# Scoping Report.

REQUEST FOR SECRETARY'S ENVIRONMENTAL  
ASSESSMENT REQUIREMENTS

## ATTACHMENT 12 SCOPING CONSULTATION – TSC

**From:** [Colleen Forbes](#)  
**To:** [Lance Newley](#)  
**Subject:** Hanson Tweed Sand Plant - Pre-SEAR's Scoping Submission / Consultation - TSC Feedback  
**Date:** Friday, 8 November 2019 1:19:17 PM

PROJECT TITLE  
**HANSON TWEED SAND PLANT**  
PHASE 5-11  
DRAWING TITLE  
CONCEPT DEVELOPMENT PHASING

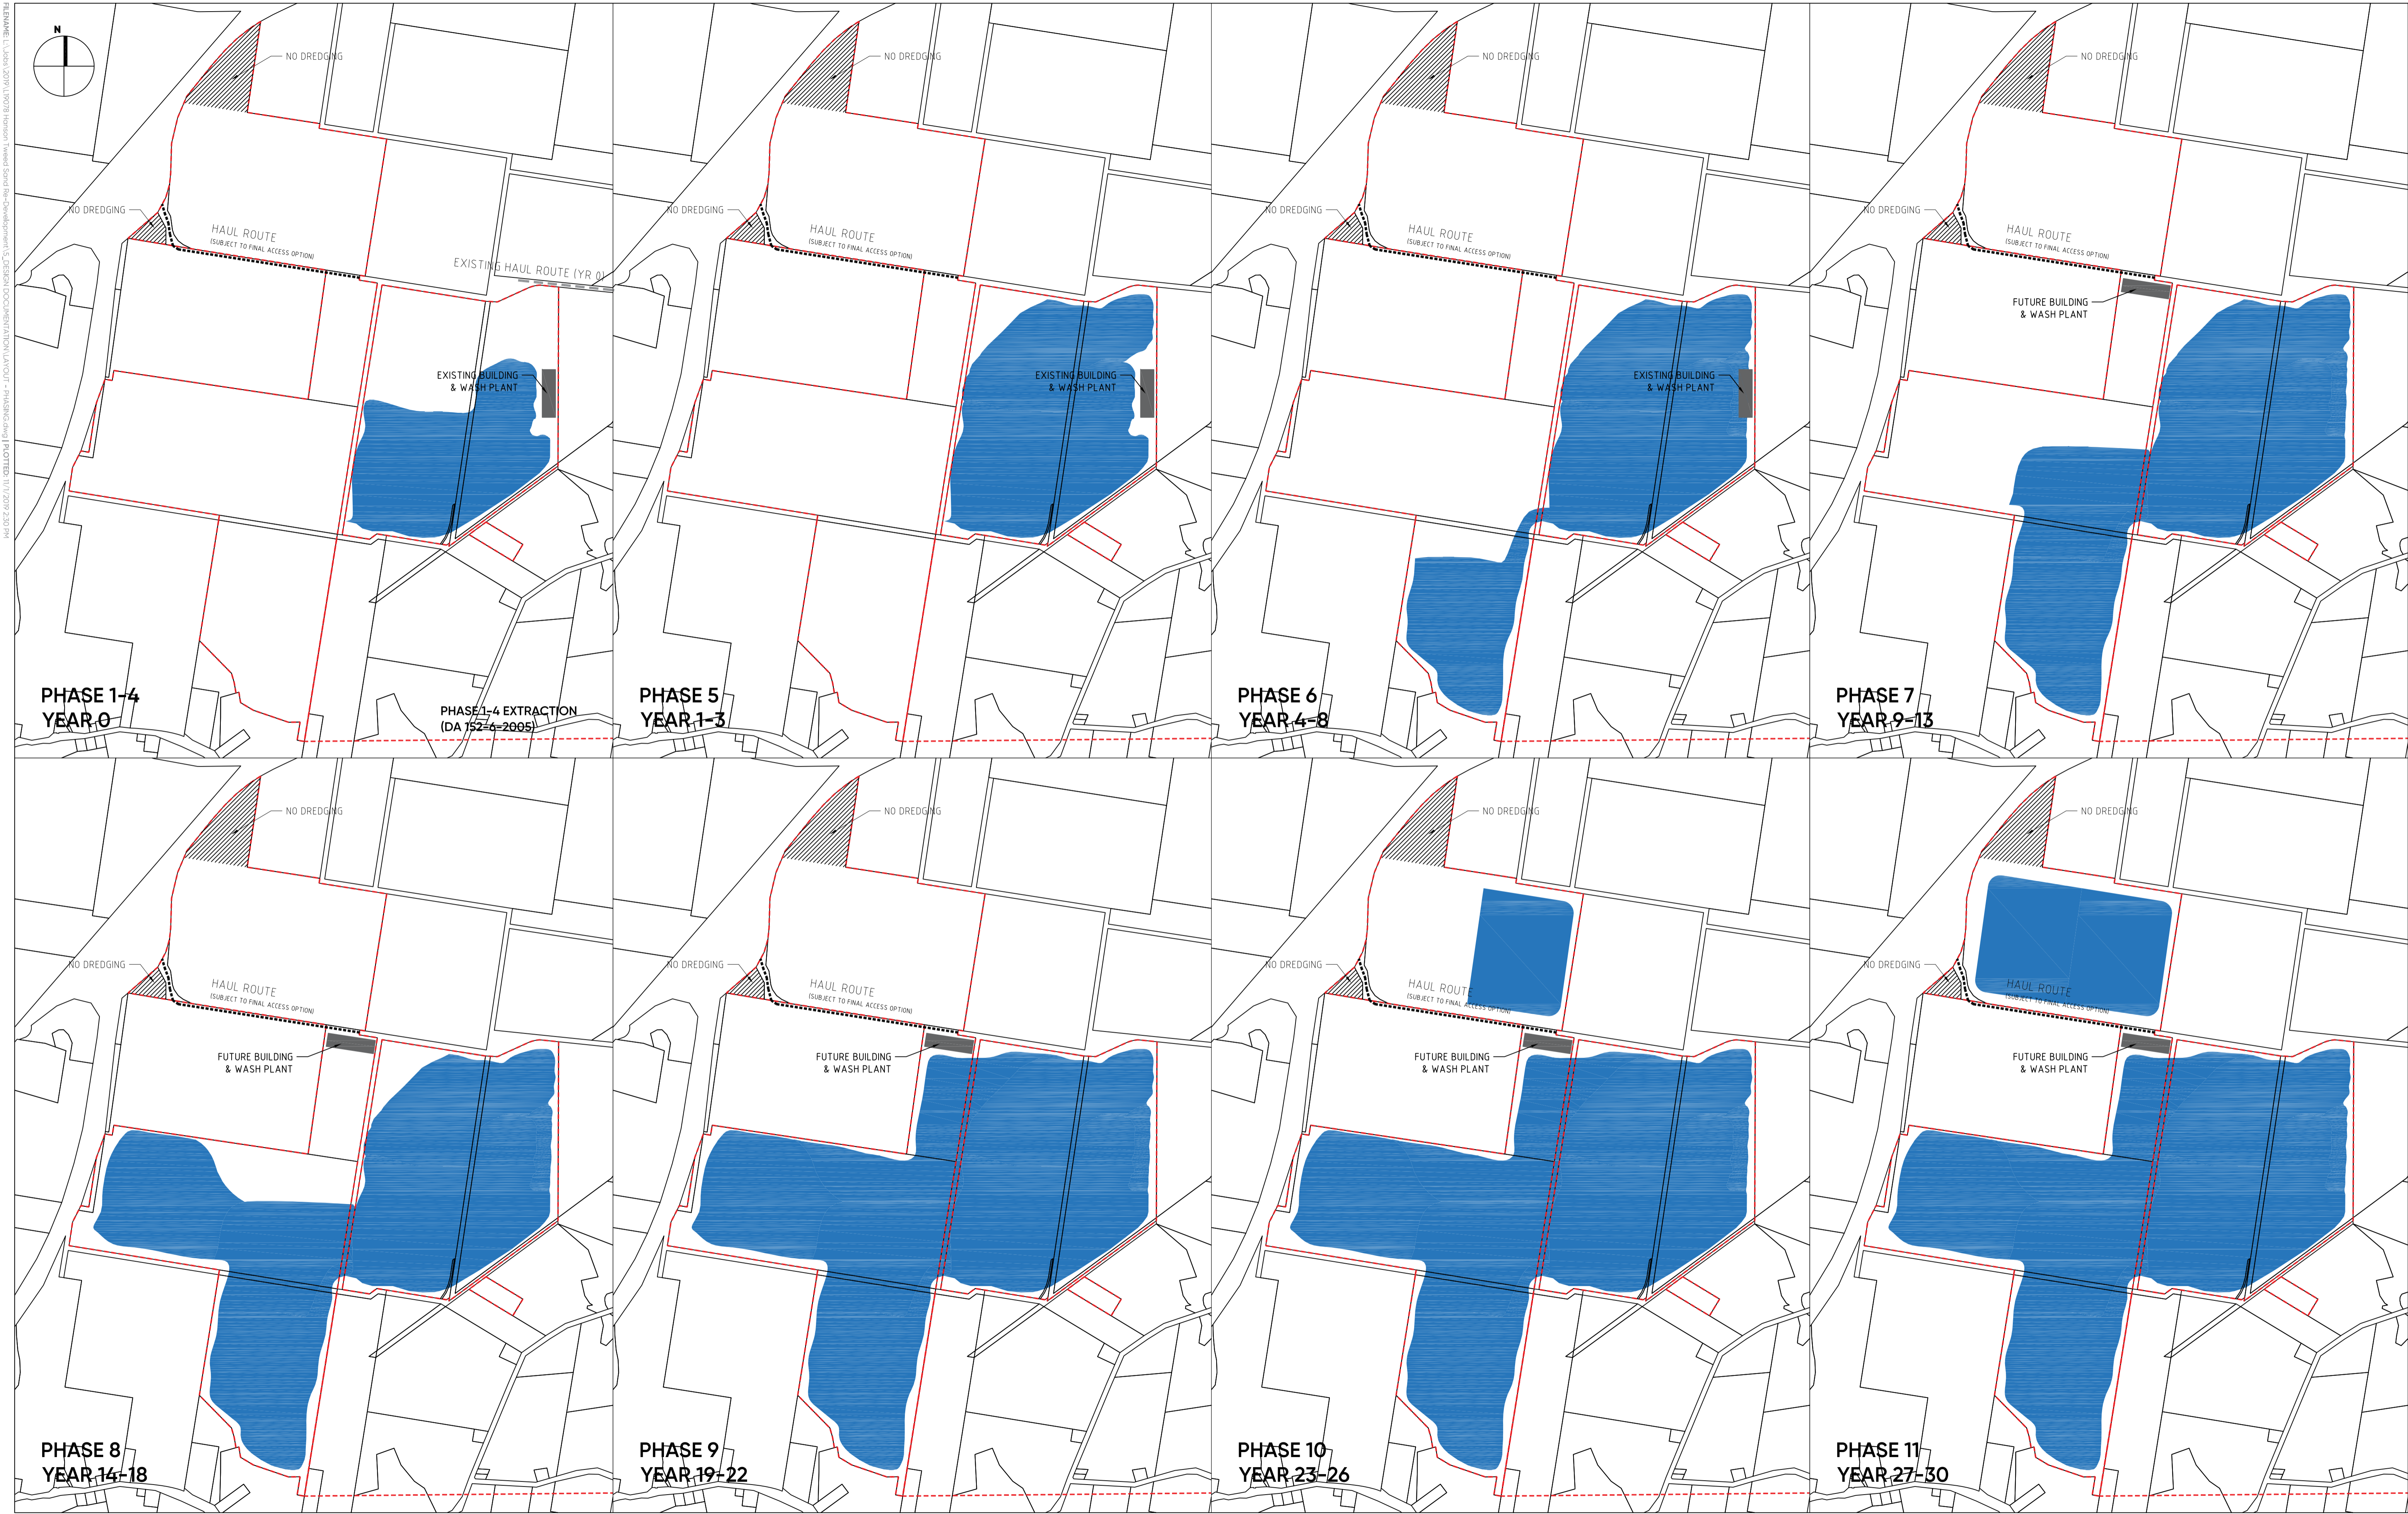
- The proposal is not clear on what the ultimate end use of the site will be and how the proposal will be maintained in the long term.
- Noise / amenity impacts associated with the proposed 24/7 hours of operation for the dredging and haulage of sand need to be investigated.
- The proposed truck routes need to be clear for all stages of the proposal. The documentation provided to date appears to indicate access to the Motorway from the initial stages of the expansion, yet the site building / wash plant does not relocate to the northern boundary until Phase 7 (Year 9-13).

END USE CONCEPT PLAN

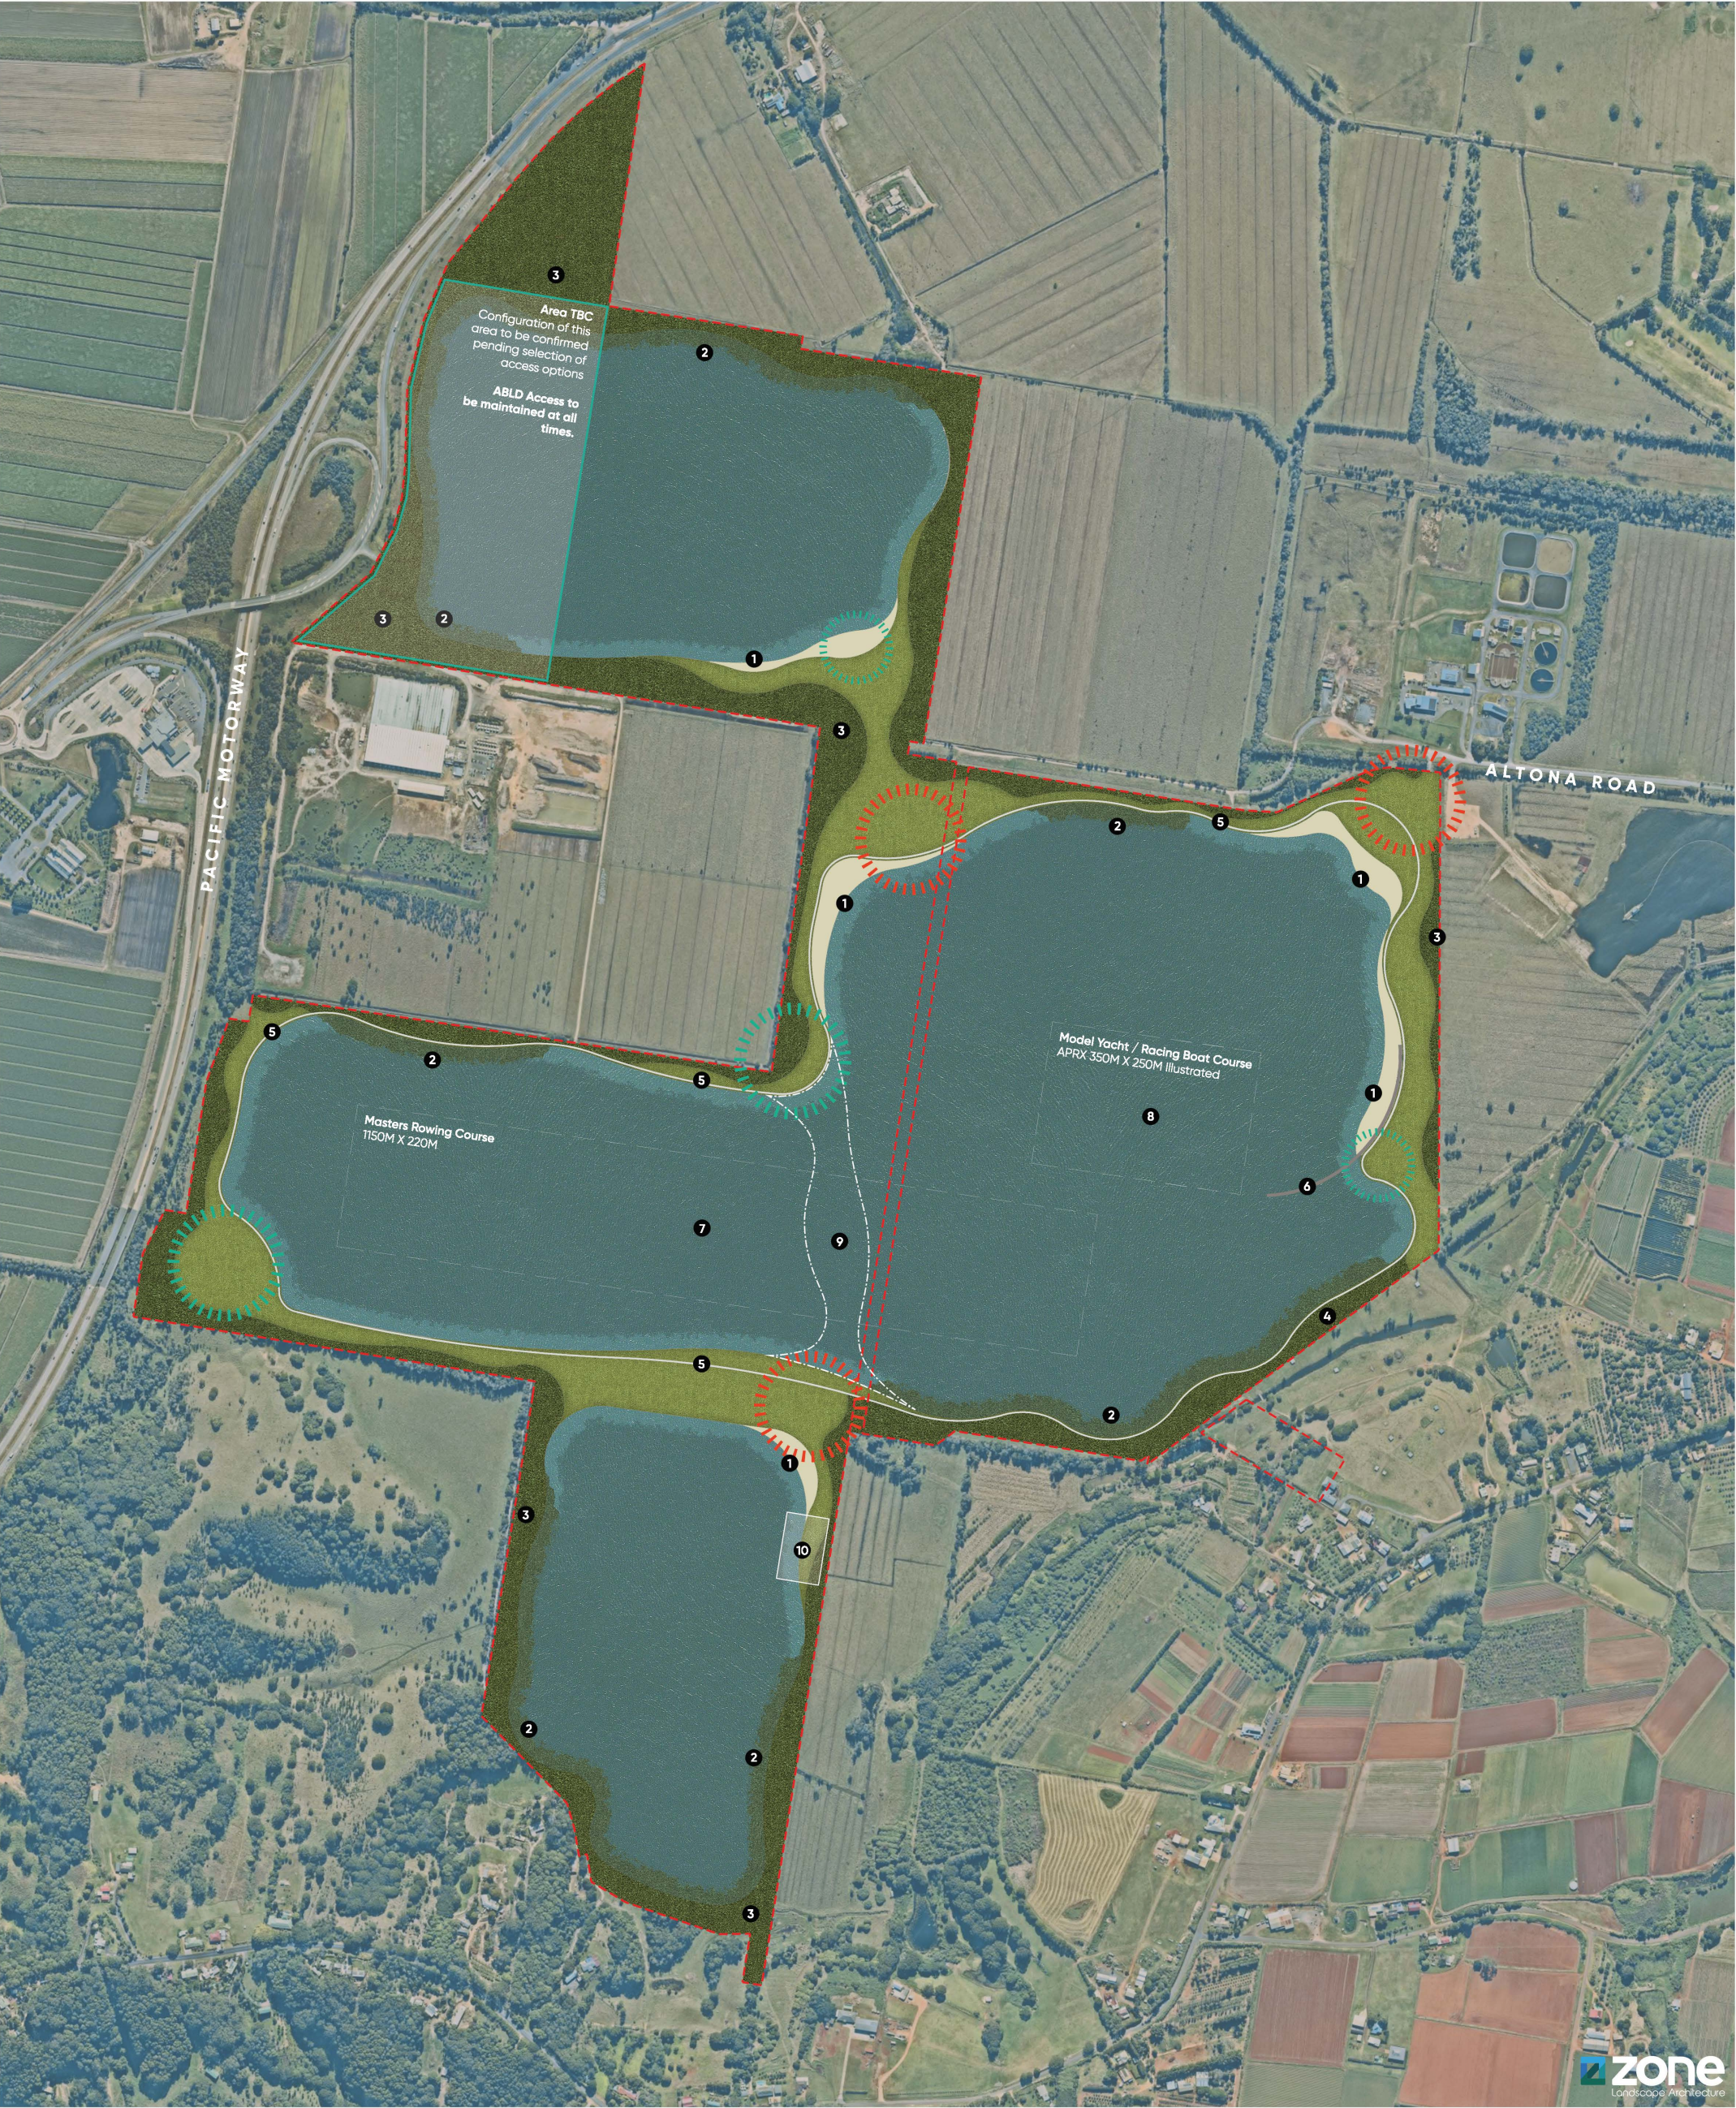
- Long term use of dredge ponds
  - The long term land use of the dredge ponds and surrounding buffers is unknown as yet. Further details of progressive remediation, post quarry closure use, management arrangements should be provided
